DEPARTMENT OF PARKS AND COMMUNITY SERVICES

March 15, 2024

Subject: Retreat at TimberRidge Filing No. 4 Final Plat (AKA TimberRidge Estates), 3rd Submittal (SF-18-027)

LOCATED IN THE SOUTHWEST QUARTER OF SECTION 22,
TOWNSHIP 12 SOUTH, RANGE 65 WEST OF THE SIXTH PRINCIPAL MERIDIAN,
EL PASO COUNTY, COLORADO

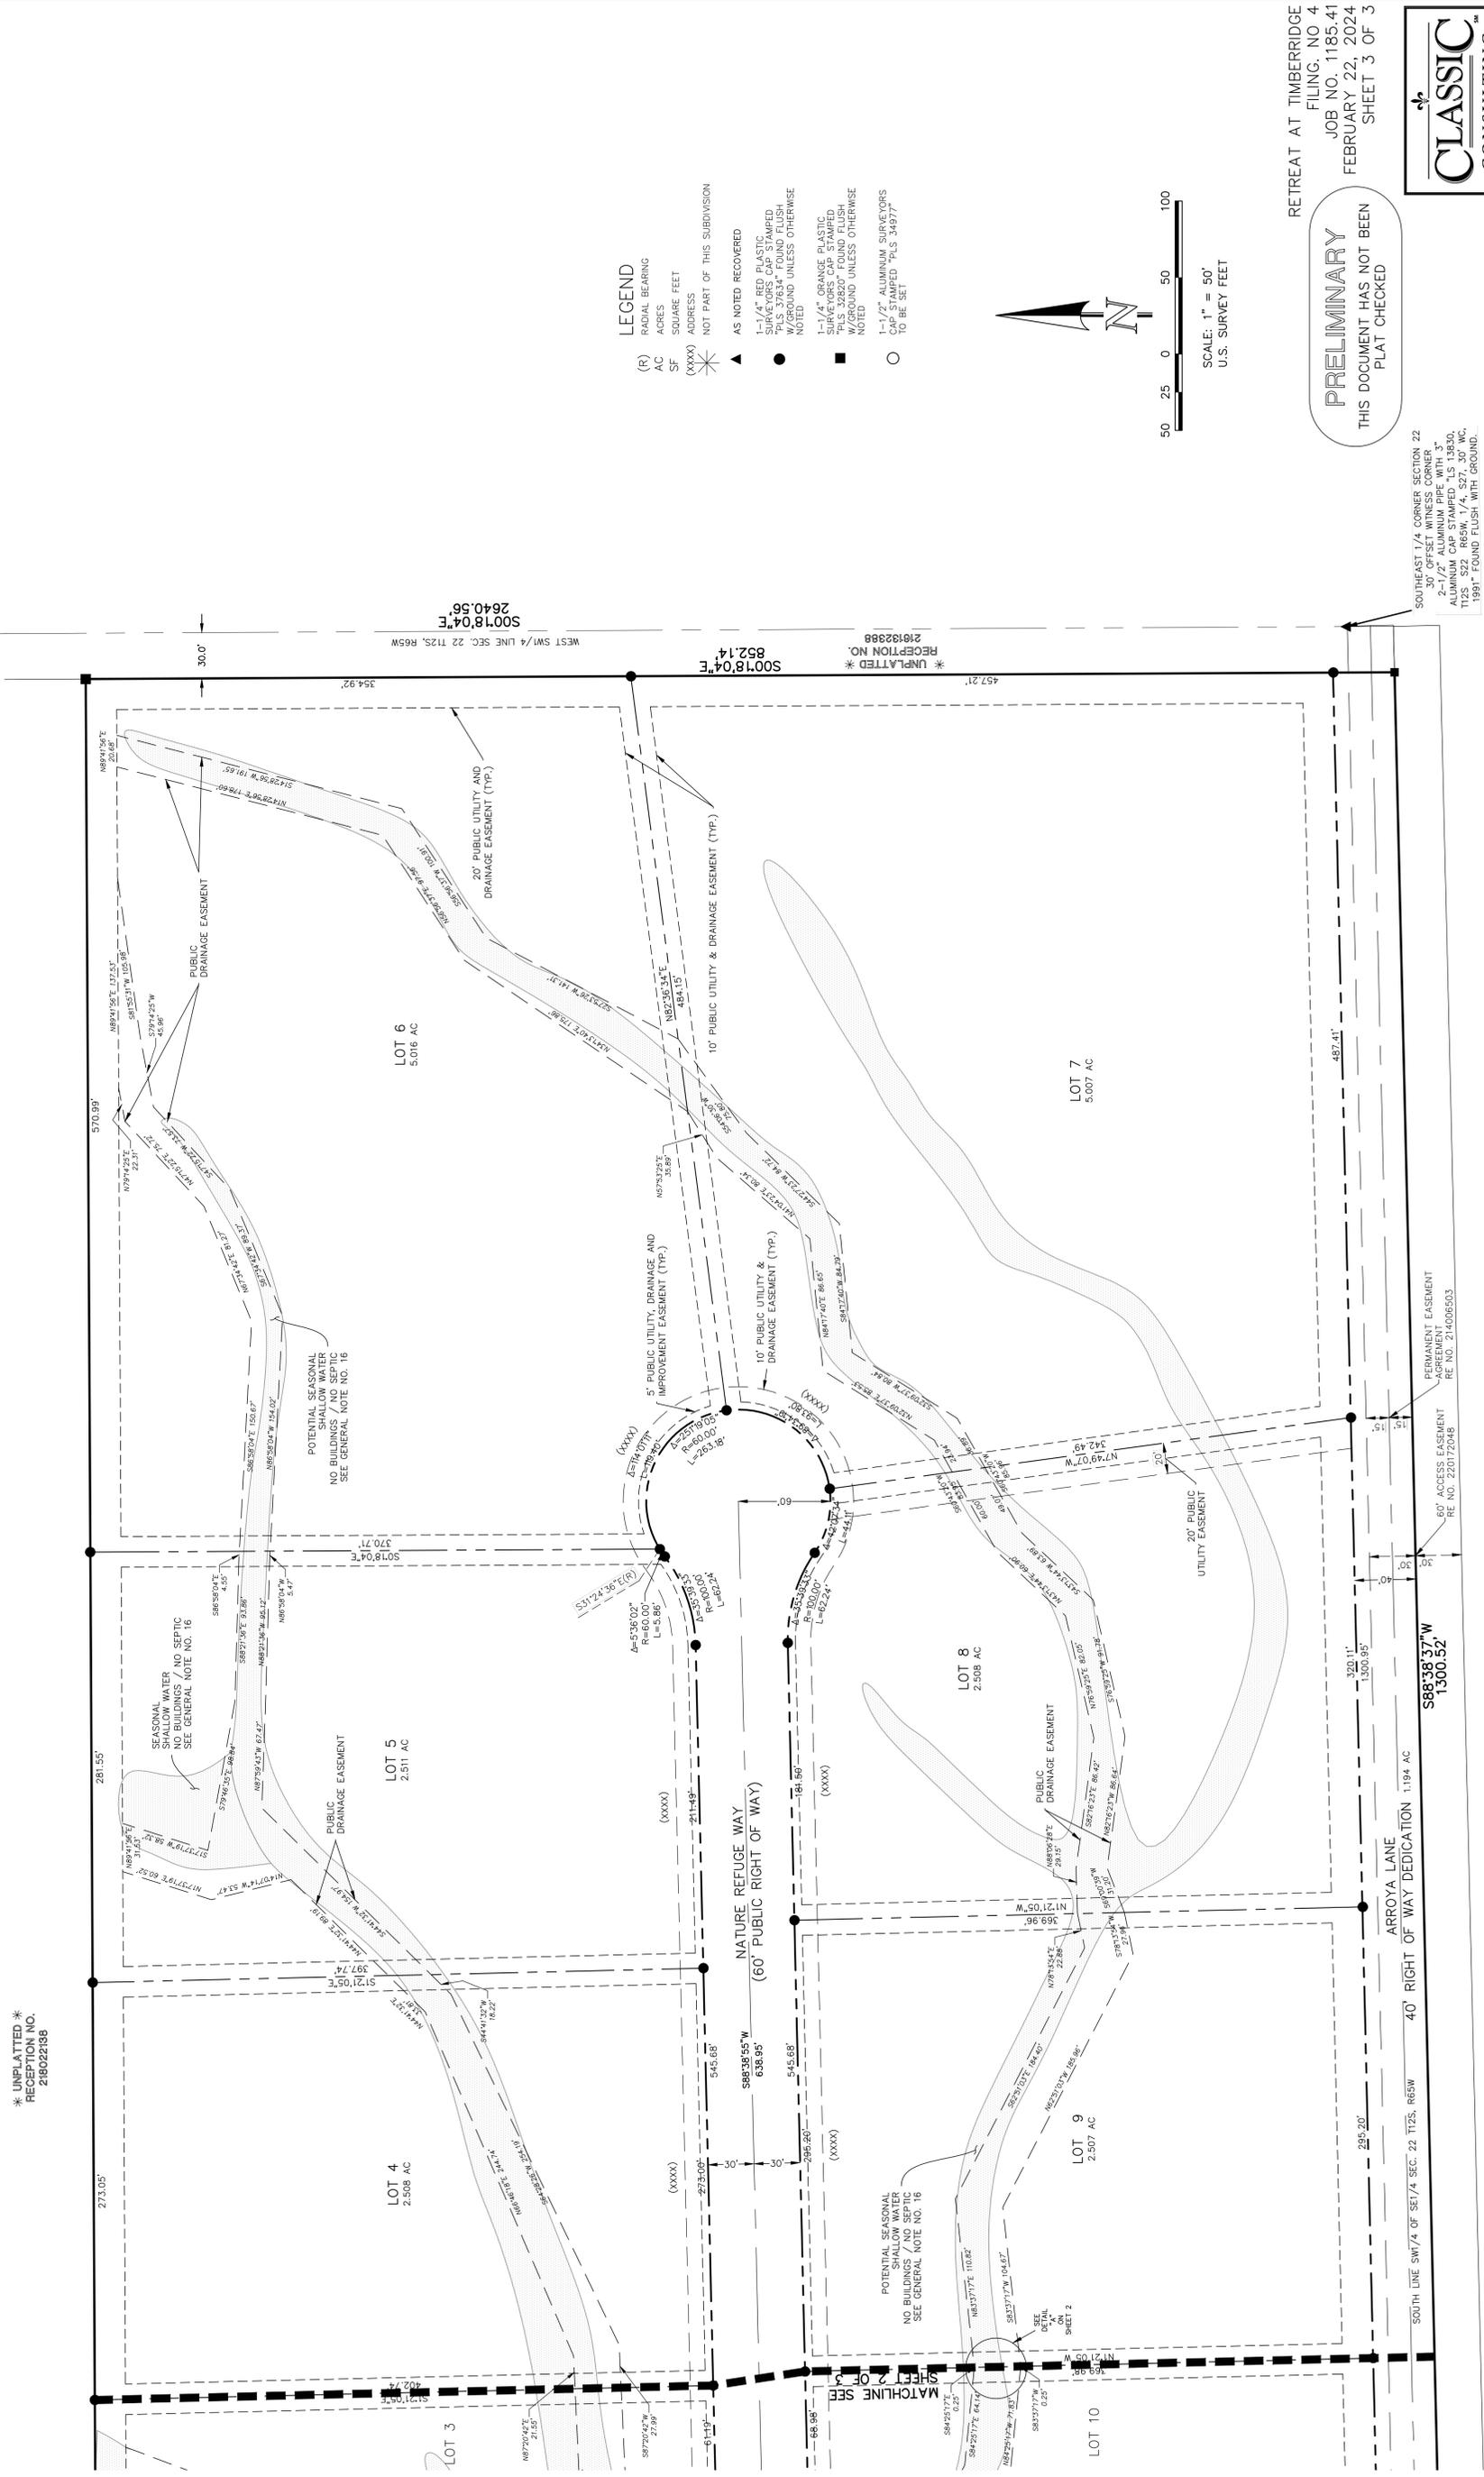
Recommend to the Planning Commission and Board of County Commissioners that approval of the **Retreat at TimberRidge Filing No. 4 Final Plat** TimberRidge Estates Final Plat include the following conditions: (1) show on the Final Plat the Sand Creek Regional Trail at the point at which the trail crosses the Arroyo Lane right-of-way; (2) require fees in lieu of land dedication for regional park purposes in the amount of **\$5,050.**"
